Group submission relating to application SSD 5878

Sydney International Convention, Exhibition and Entertainment Centre Precinct –
Mixed use Development in the Southern Haymarket Precinct (Concept Proposal) (SSD)

Figure 5.3. Building heights site diagram

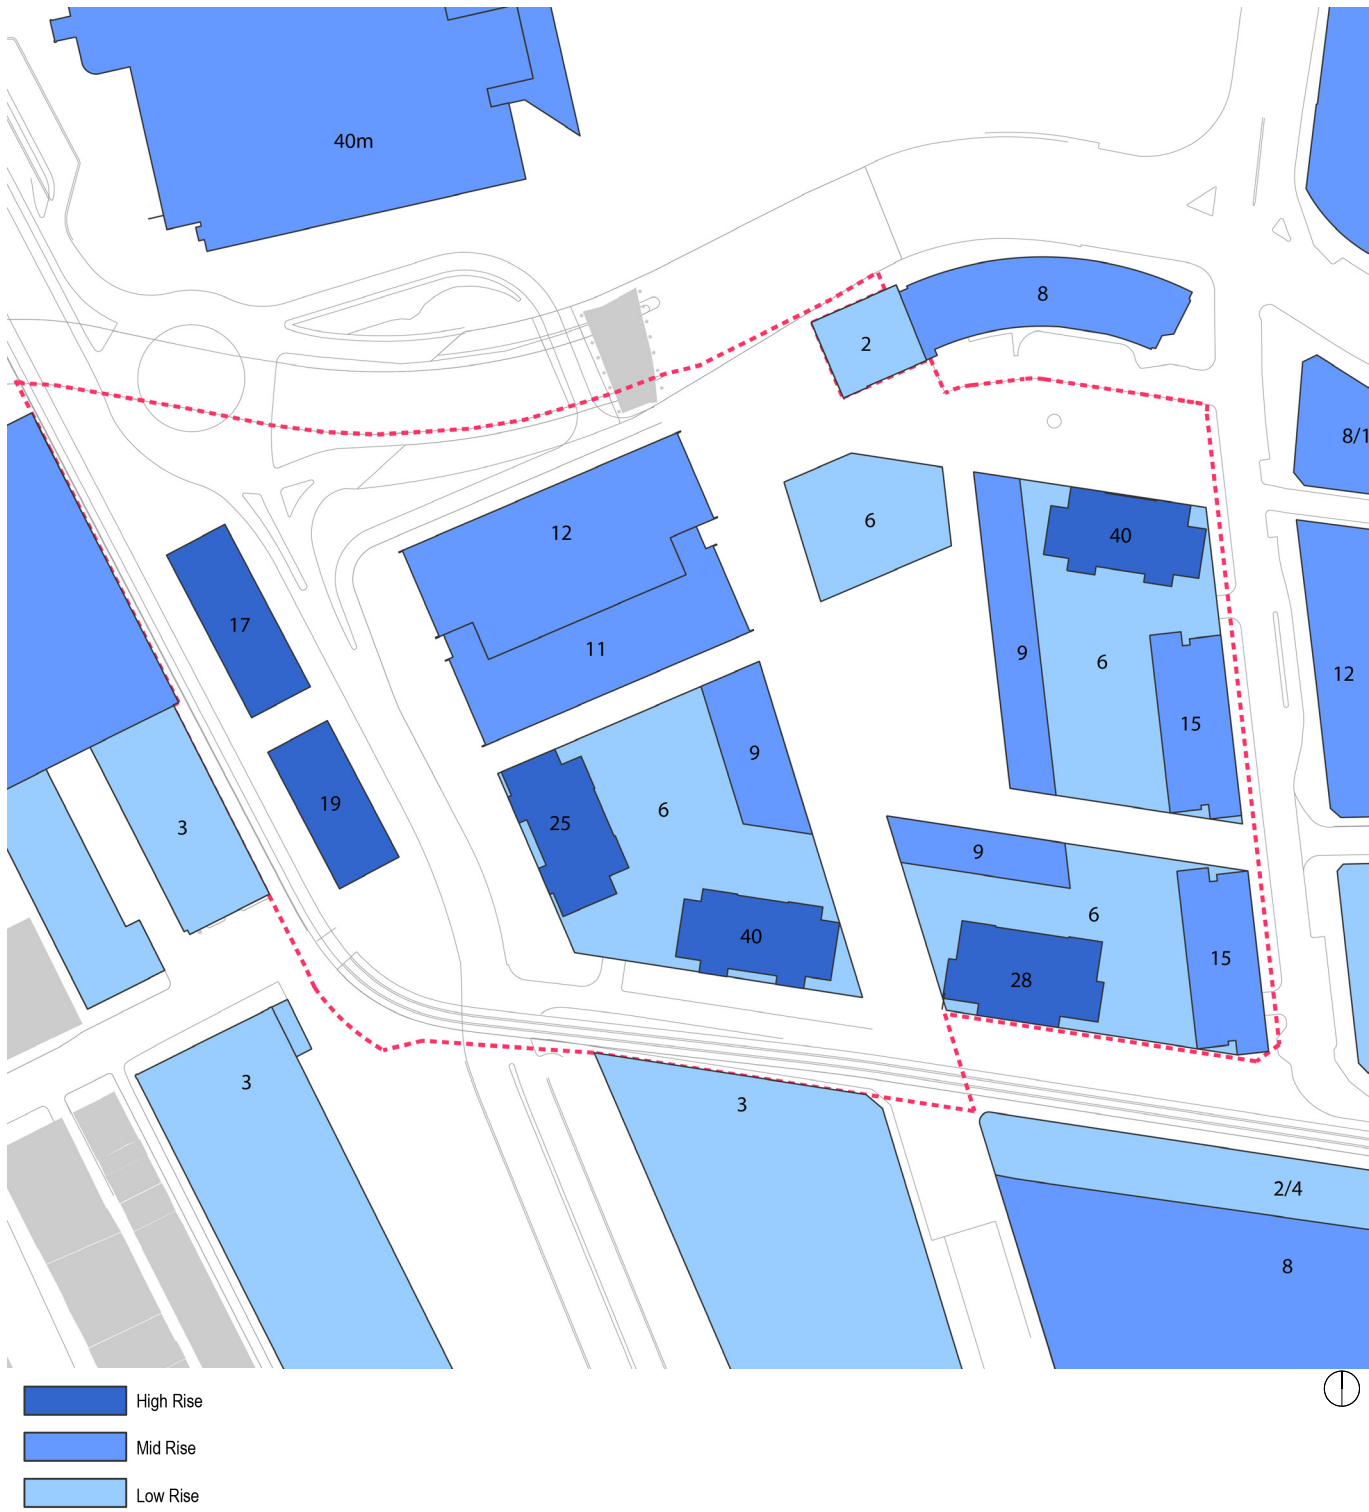
Each of the nine buildings has a proposed depth greater than the maximum 18 metres specified in the Residential Flat Design Code, and the developer fails to address the specific criteria in the Code under which the maximum may be exceeded.

The proposed building depths of the nine buildings are given in section 5.6.4 on page 88 of the EIS. They range from 19 metres to 24 metres.

It can be seen that each of the nine buildings has a proposed depth greater than the 18 metre guideline. The largest excess is 6 metres, which is 33% above the 18 metre guideline, but which the EIS describes as being a "relatively minor variation".

It is incumbent upon the developer to demonstrate why deeper plans than the guideline of 18 metres are acceptable in each of the nine buildings. Are higher floor to ceiling heights being proposed? Are wider frontages being proposed? The EIS is silent on these issues. Rather than addressing the specific criteria in the Controls under which deeper plans than 18 metres may be approved, the EIS simply makes the following vague promises:
